Recommendation Report for Planning Permission for Works or Extension to a Dwelling

REF NO: R/21/26/HH

LOCATION: 69 Worthing Road
Rustington
BN16 3JU

PROPOSAL: First floor rear extension (revised proposals to R/146/25/HH). New vehicular drop kerb.

SIDE (w)

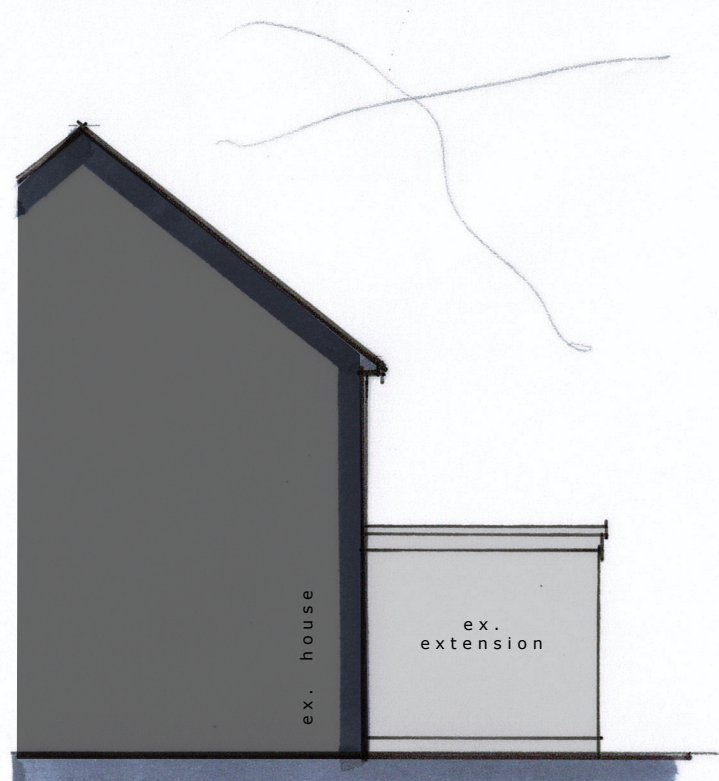
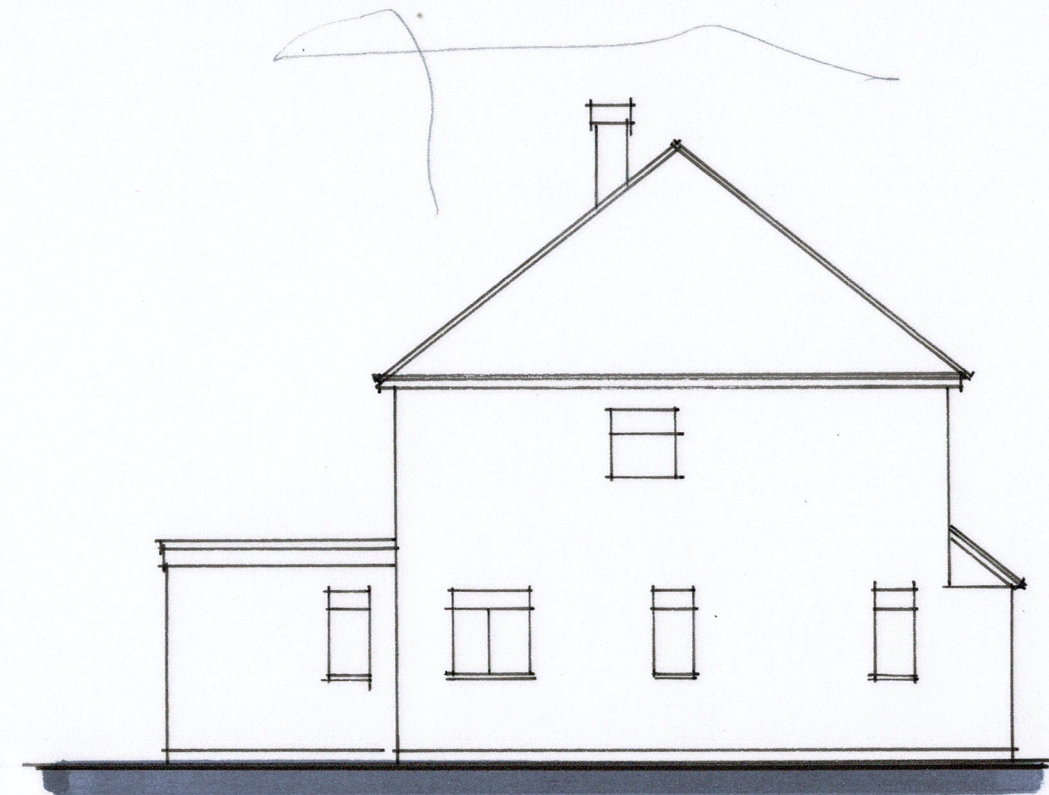
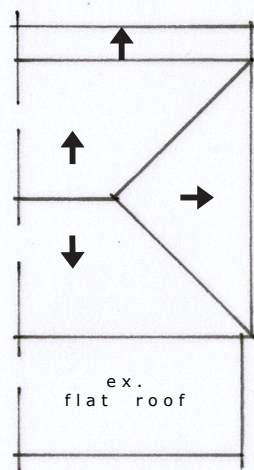
The first floor rear extension would measure 6m wide and 3m deep. Two windows are proposed on the rear (south) elevation and a splayed northwest corner. In terms of materials, the walls of the extension would be finished in composite cladding, with the windows being grey powder coated aluminium uPVC. The size and scale of the extension would appear appropriate for the host dwelling. Furthermore, the elevational treatment would match the existing dwelling, and the materials would be appropriate. The extension would have a flat roof which would be set down from the main ridge line of the host dwelling, and the rear extension would not be readily visible from Worthing Road. The extension would not appear prominent within the street scene and would be acceptable in this regard.

The flat roof of the first floor extension would be set above the existing eaves of the host dwelling. Following the previous refusal, the extension has been amended to incorporate a splayed form. While unusual in appearance, Worthing Road has various forms of extensions and roof forms; the introduction of the flat roof, splayed extension would not appear out of character, resulting in no harm to design or visual amenity. The extension would be in accordance with the Arun Design Guide (ADG) guidance regarding back-to-back or back-to-side first floor distances.

69 WORTHING ROAD, RUSTINGTON
Proposals 03 Rev A
July 2025

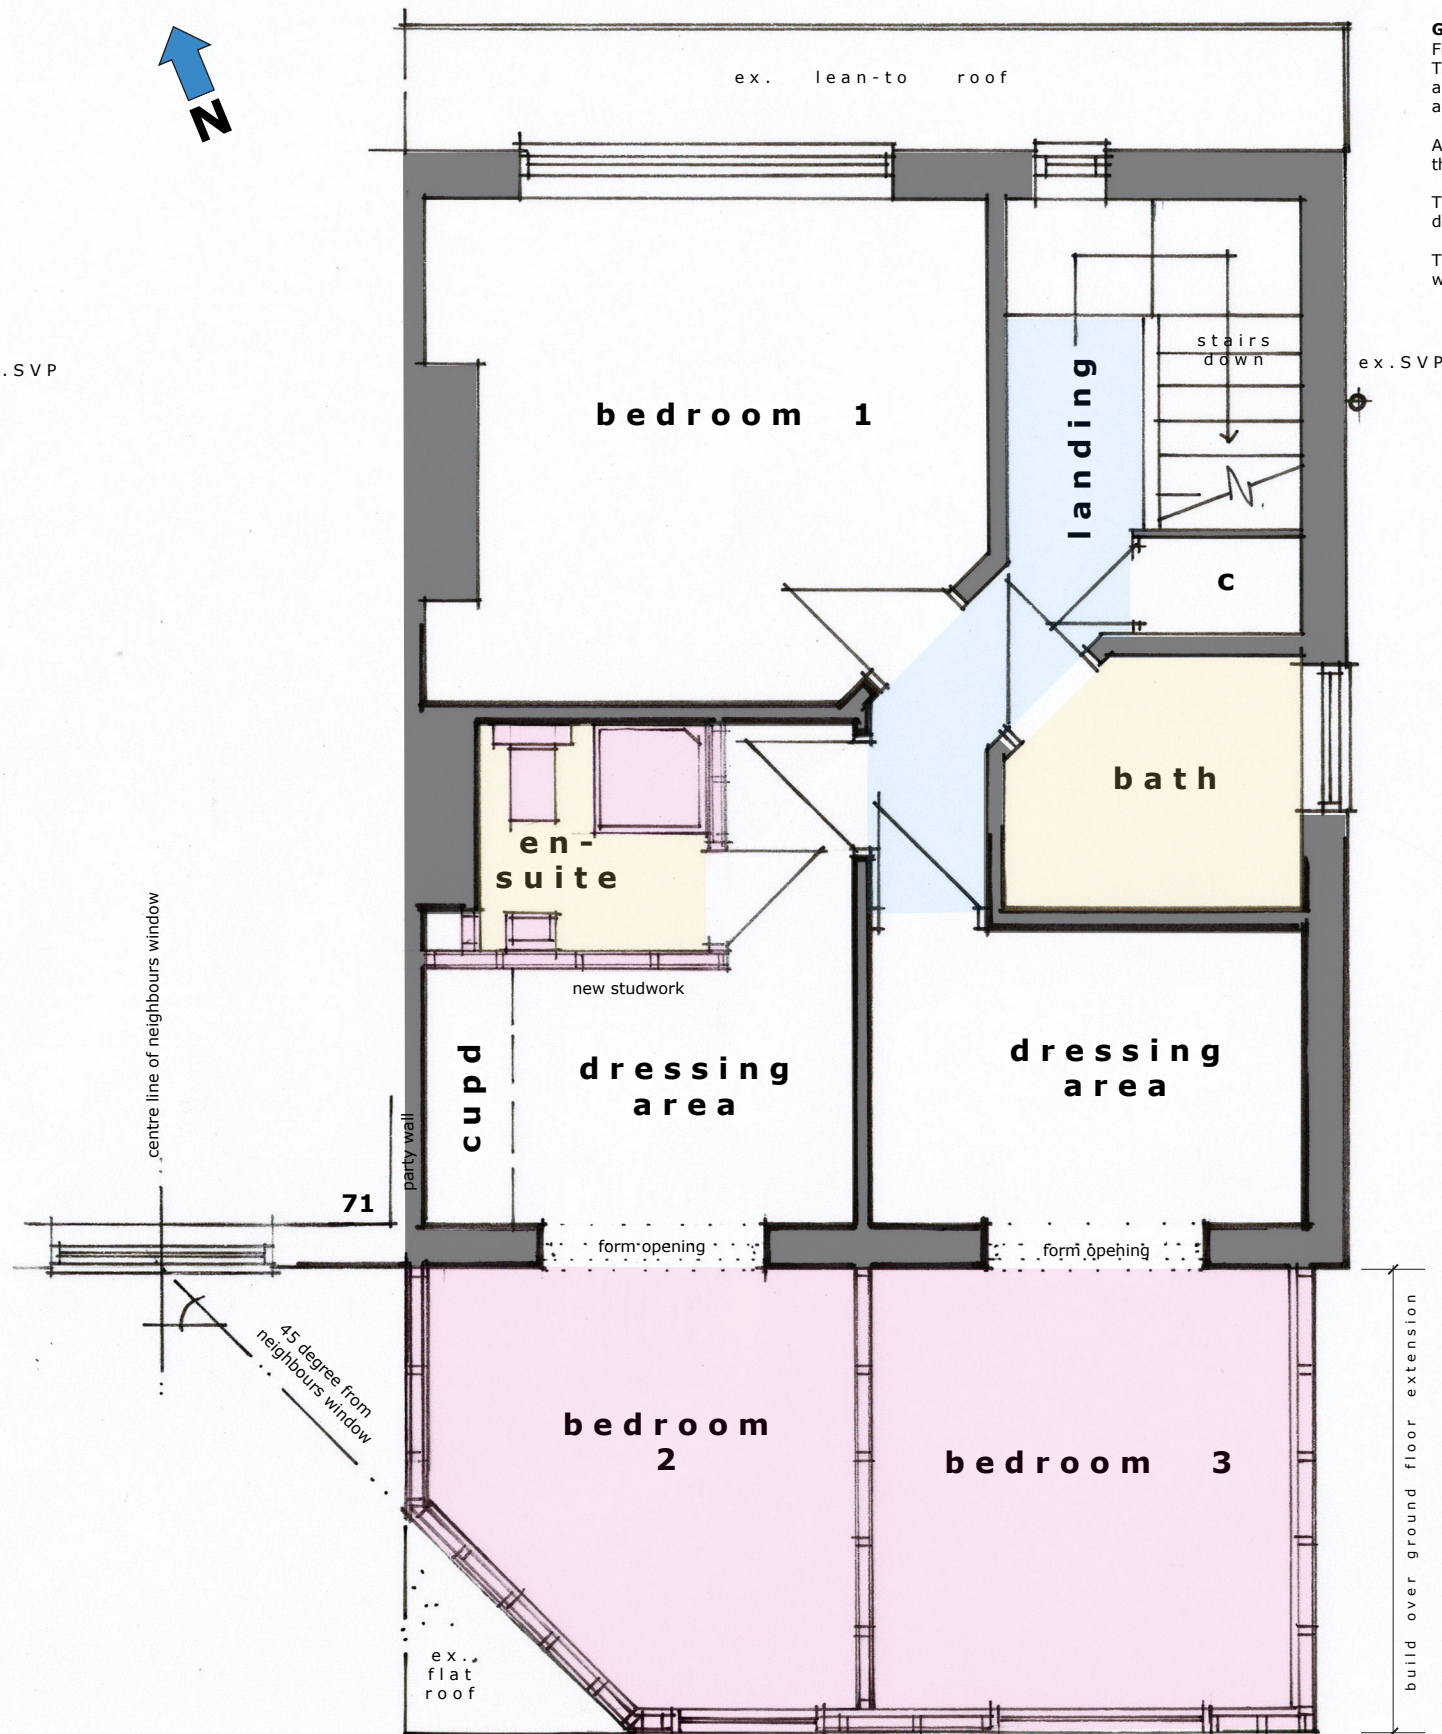
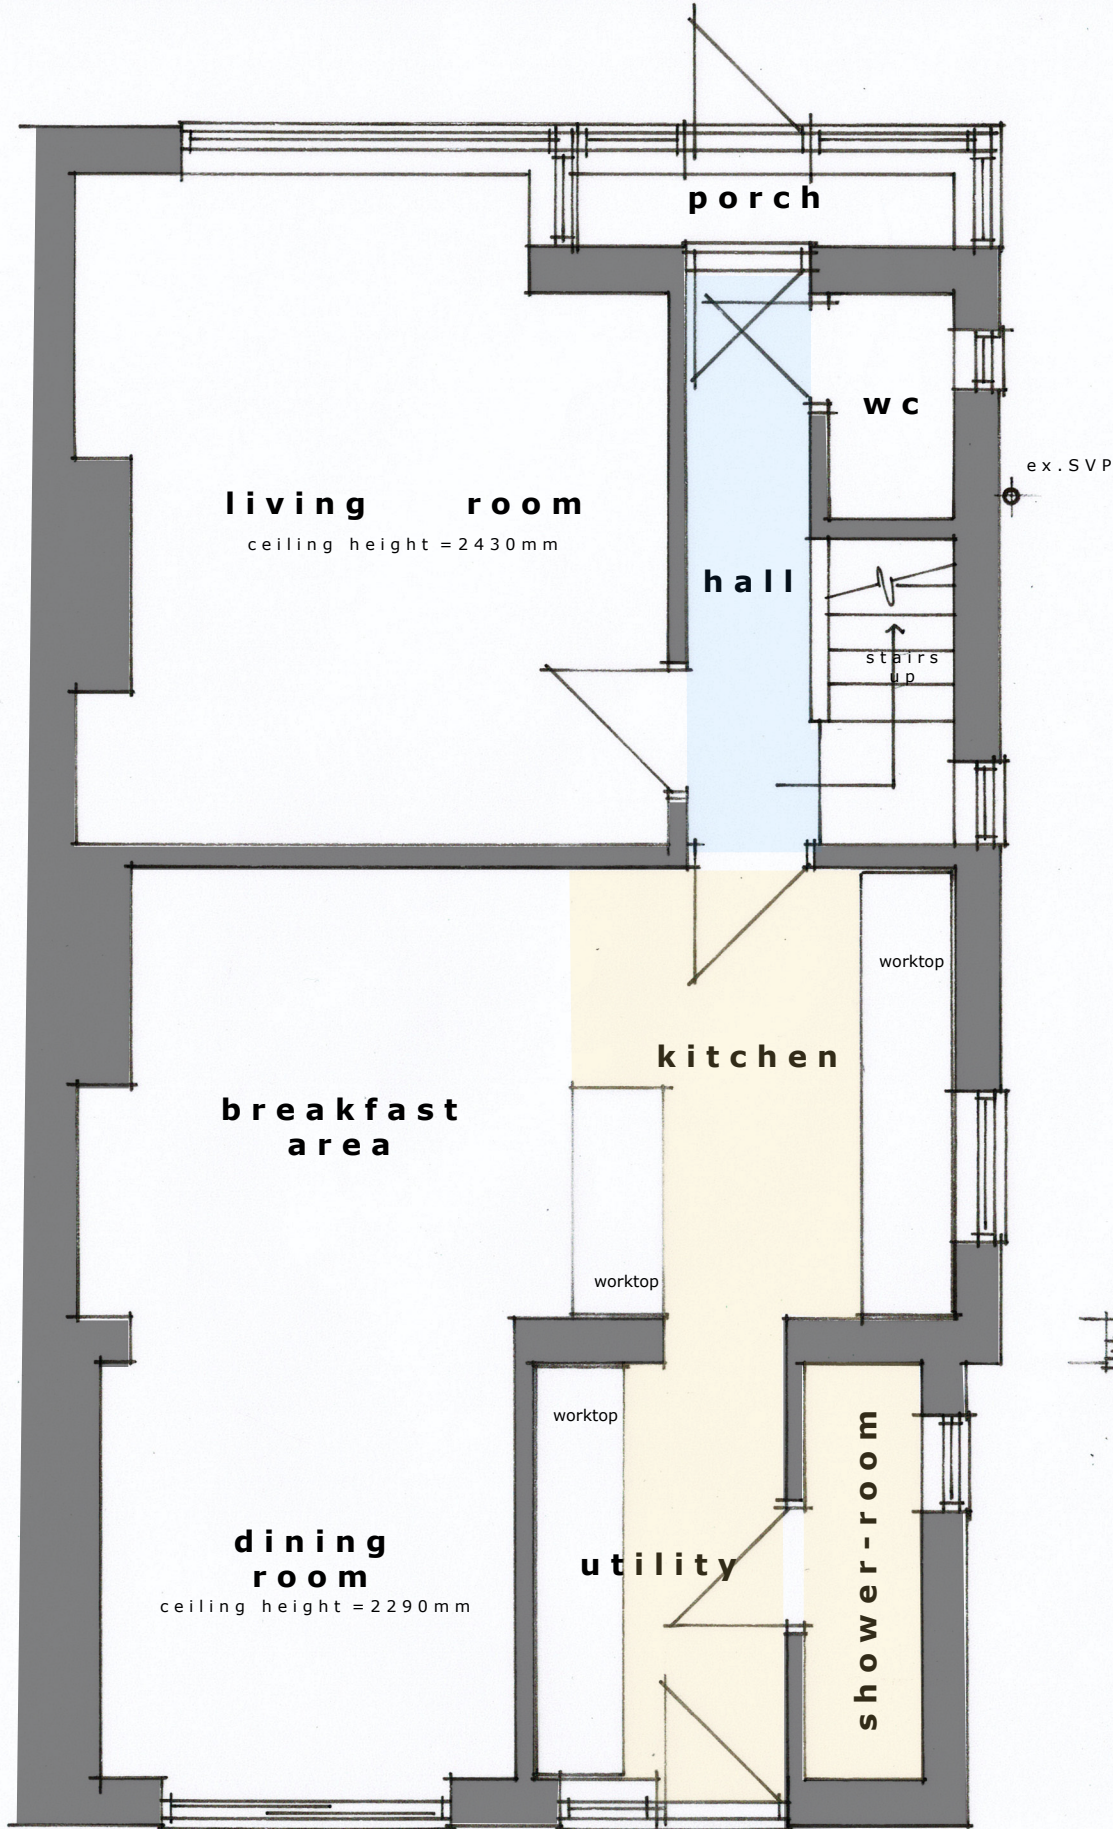
The site includes a semi-detached dwelling with a garage and outbuilding. The application is for a first floor rear extension and new vehicle crossover, following a previous refusal for a first floor rear extension. The proposal has been amended to incorporate a splayed design following concerns raised over undue harm by way of overbearing and overshadowing impacts. The works would not be visible from Worthing Road, but views of the extension would be available from Jubilee Avenue.

The proposed windows would be rear facing and look over the rear garden and private parking areas to the rear of the site. No windows are proposed along the side elevations of the extension. There would be no significantly adverse impacts by way of overlooking of neighbouring properties.
